**Consultation Response from KC,
Lead Local Flood Authority**
2022/92194 Land adj, 21, Thomas Street, Lindley, Huddersfield, HD3 3JJ
Outline application for erection of care home (Use Class C2) of up to 60 beds with associated access
Date Responded: 19/08/2022
Responding Officer: Martin Stephenson
Responding Ref: 0
Documents reviewed by the LLFA:

- Drawing Ref: H.21.81 (9-) 2, Proposed Site Plan, Rev G dated 21/06/2022

- Document Ref: HYD710-THOMAS.STREET-FRA&DMS, FRA and Drainage Management Strategy, Rev 1.1 dated 11/05/2022

APPENDIX K: PRELIMINARY DRAINAGE STRATEGY

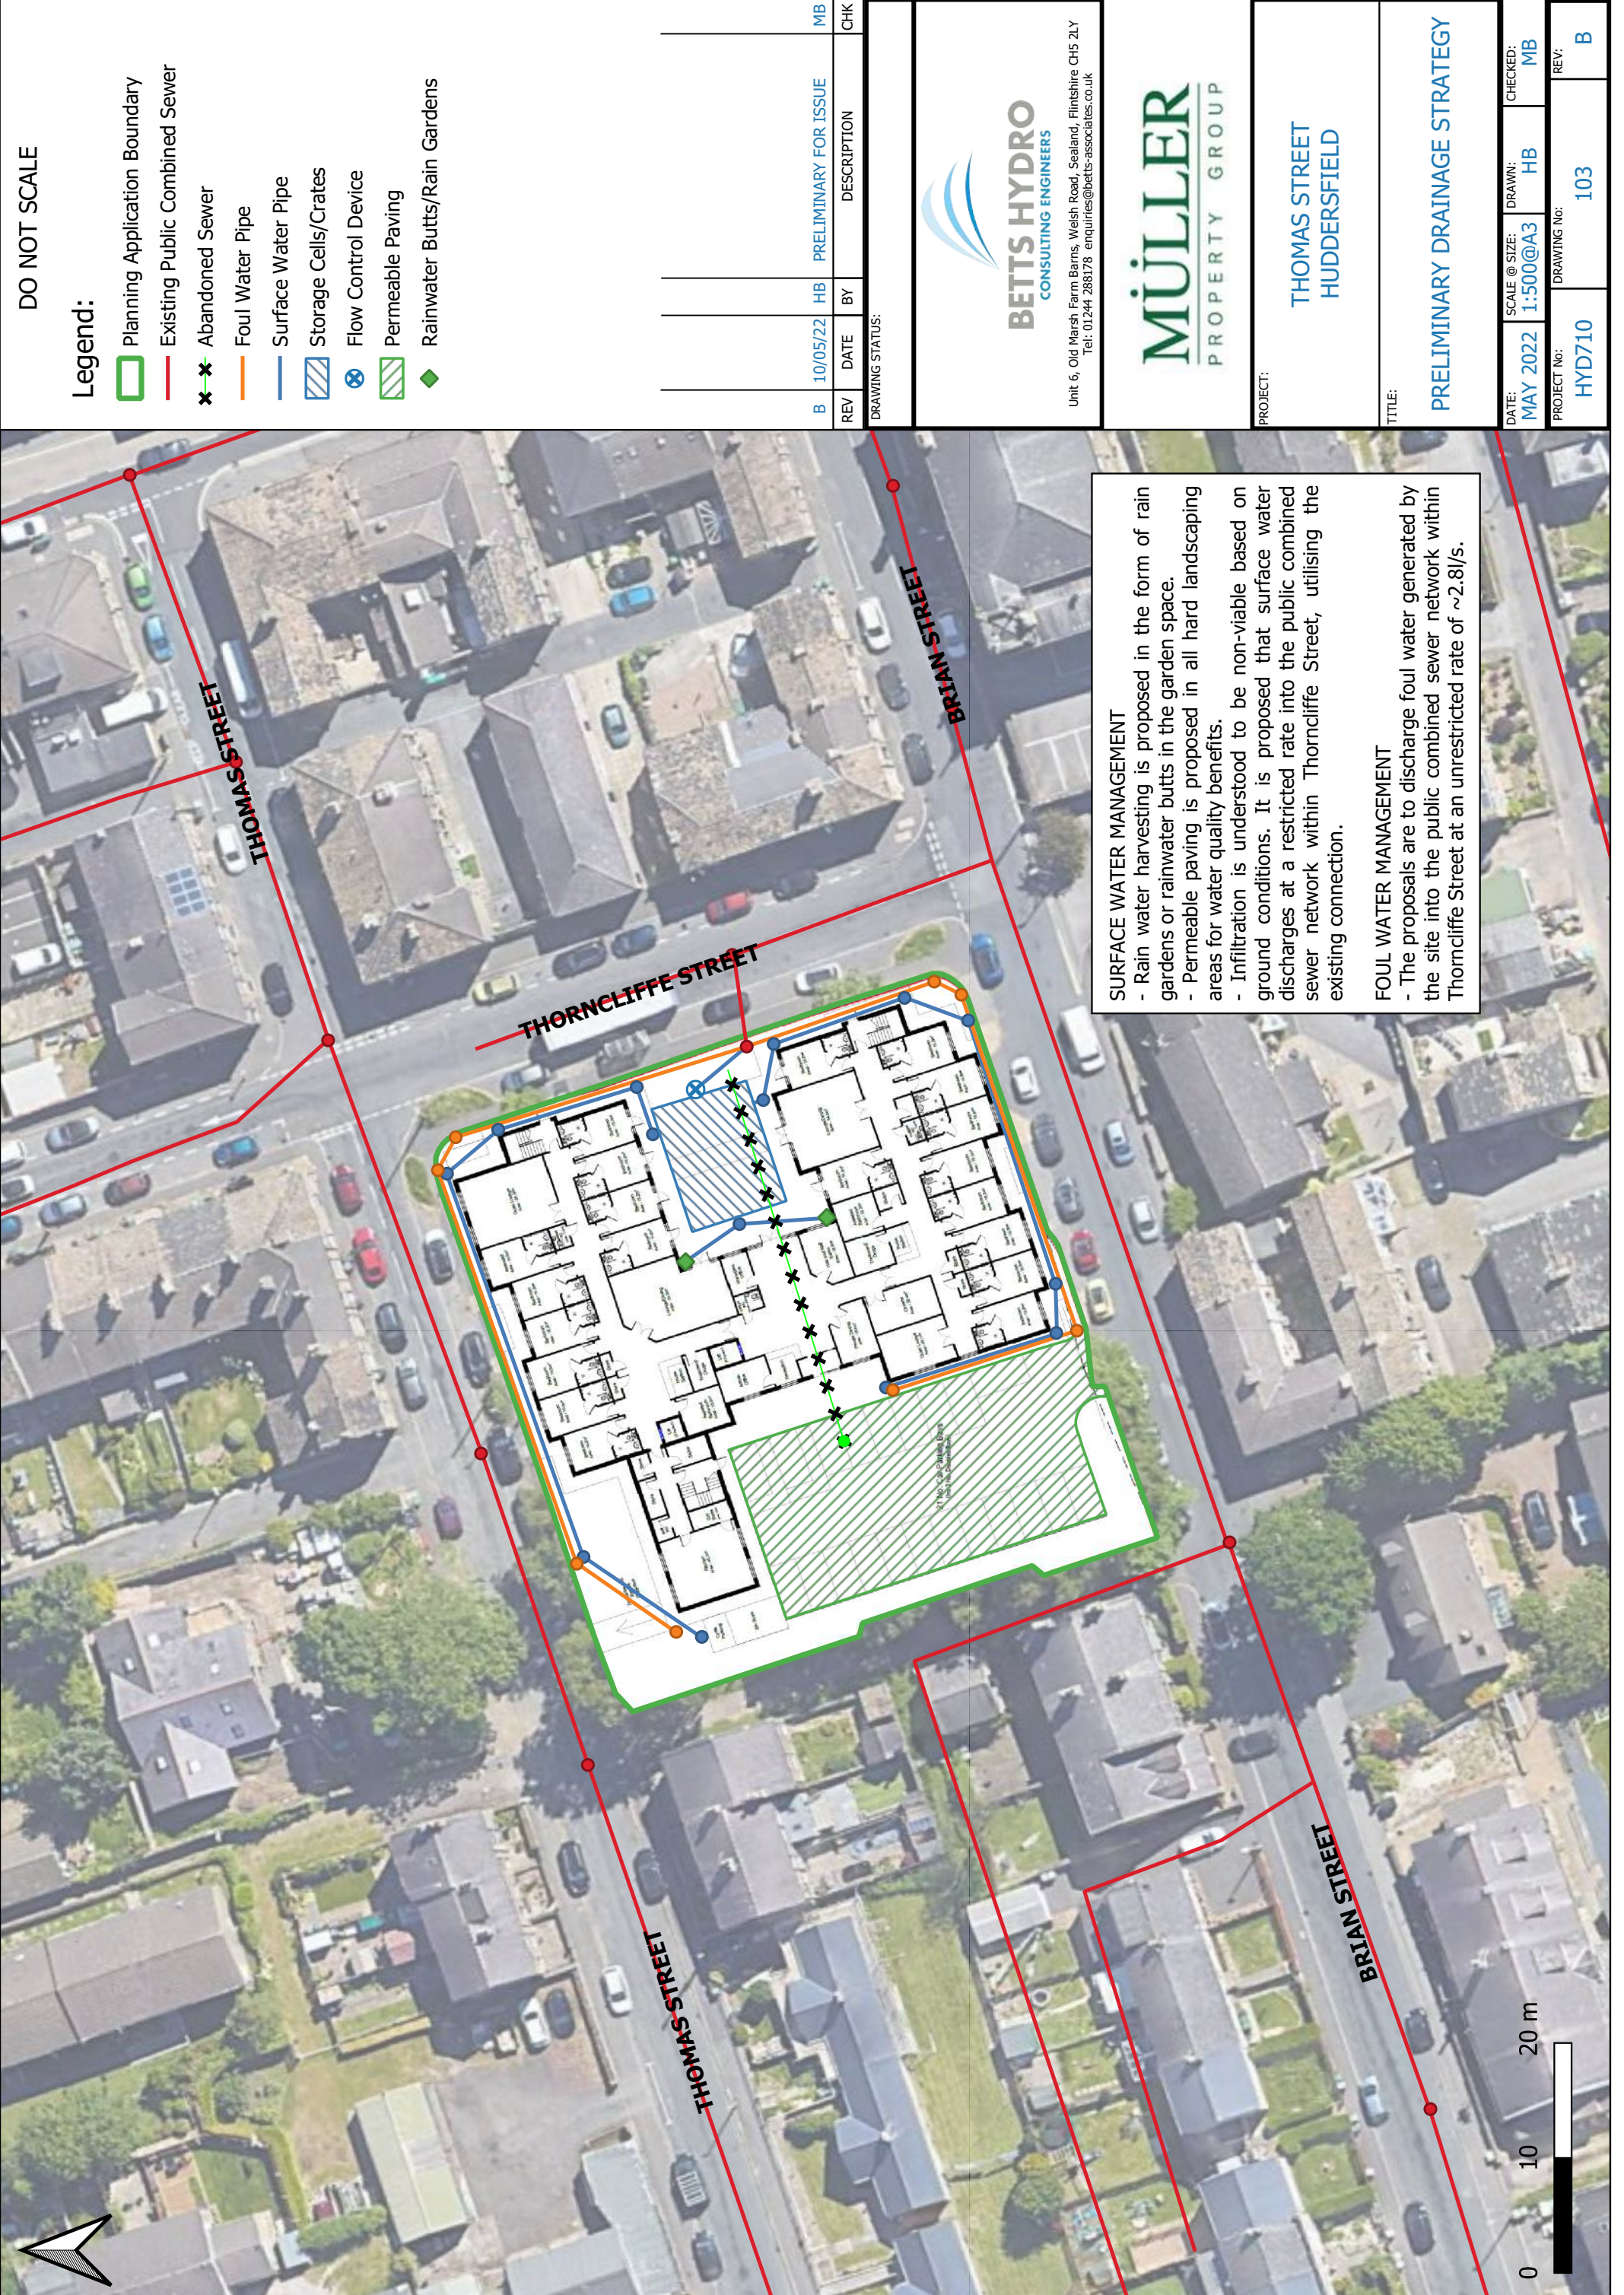
However, The LLFA notes that the proposed flow control is to be an orifice plate. It is preferred that the flow control device should be of the vortex type (such as a HydroBrake or similar) as these devices are less prone to blockage. The minimum outlet diameter of the device should preferably be 100mm or an absolute minimum of 75mm.
